Reference No: 2020/44/92431/W

Site Address: 345, Bradley Road, Bradley, Huddersfield, HD2 1PR

Description: Discharge conditions 3, 4, 7 on previous permission 2019/91083 for demolition of existing dwelling and erection of detached dwelling with detached garage/store

2020/92431– Officer Report

Facing Materials

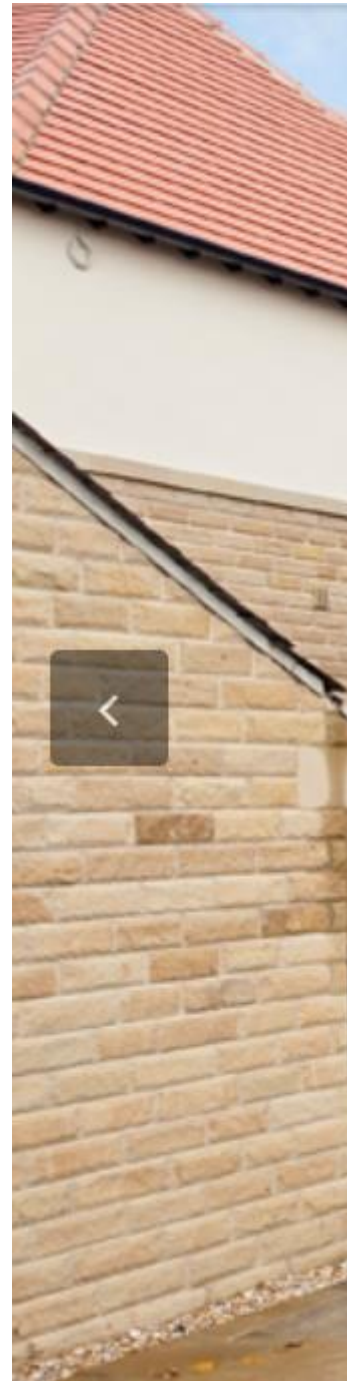
There is a varied character to dwellings along Bradley Road. There are numerous examples of natural stone being used for ground floor/plinths to dwellings with render above. In this context the proposed natural stone, which is of a colour which harmonises with existing stone in the area, is visually acceptable.

These materials are considered visually acceptable in the context of the street scape and are approved for use.

Proposed Roofing Tile

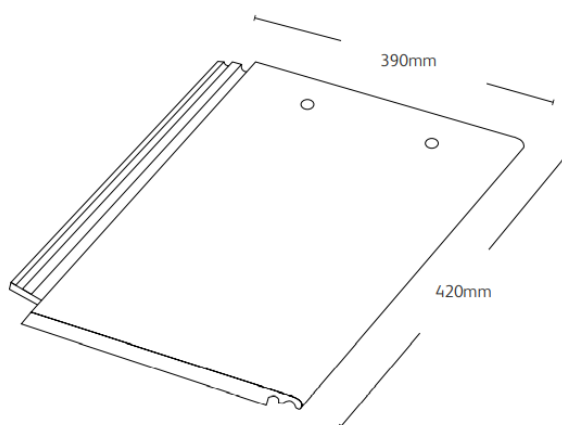
The proposed concrete roof tile, which would have a flat profile and thin leading edge, would mimic blue slate. There are numerous examples of blue slate – and other flat profile tiles – being used as roofing materials in the locality. In this context the proposed roof tile would be visually acceptable.

Boundary Screens

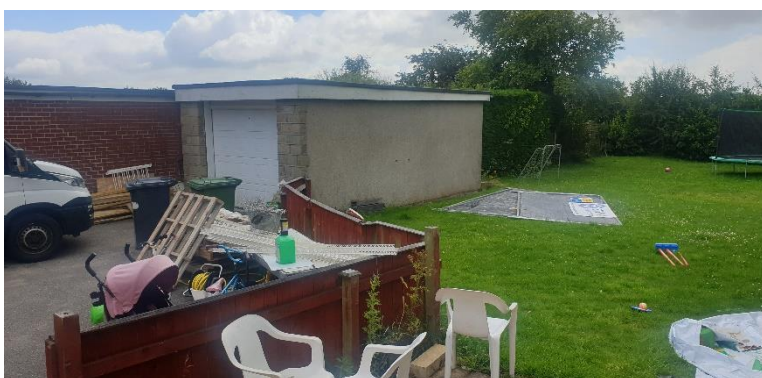
Although the general fencing is acceptable, and would retain the privacy of residents of adjoining properties, there is some concern that the height of the fence close to the boundary with Bradley Road could hinder visibility for drivers leaving both nos. 343 and 345. This would not be in the interests of highway safety. The applicant has been approached to provide clarification on this point. Condition 7 cannot be approved at this time

Although the fencing is generally acceptable, and would retain the privacy of residents of adjoining properties, I am concerned that the height of the fence close to the boundary with Bradley Road could hinder visibility for drivers leaving both nos. 343 and 345. This would not be in the interests of highway safety. Condition 7 cannot be discharged at this time.

Please provide further information/clarification regarding the height and location of the fencing to sam.jackman@kirklees.gov.uk and teresa.harlow@kirklees.gov.uk within 2 weeks of this letter quoting application no. 2020/92431.
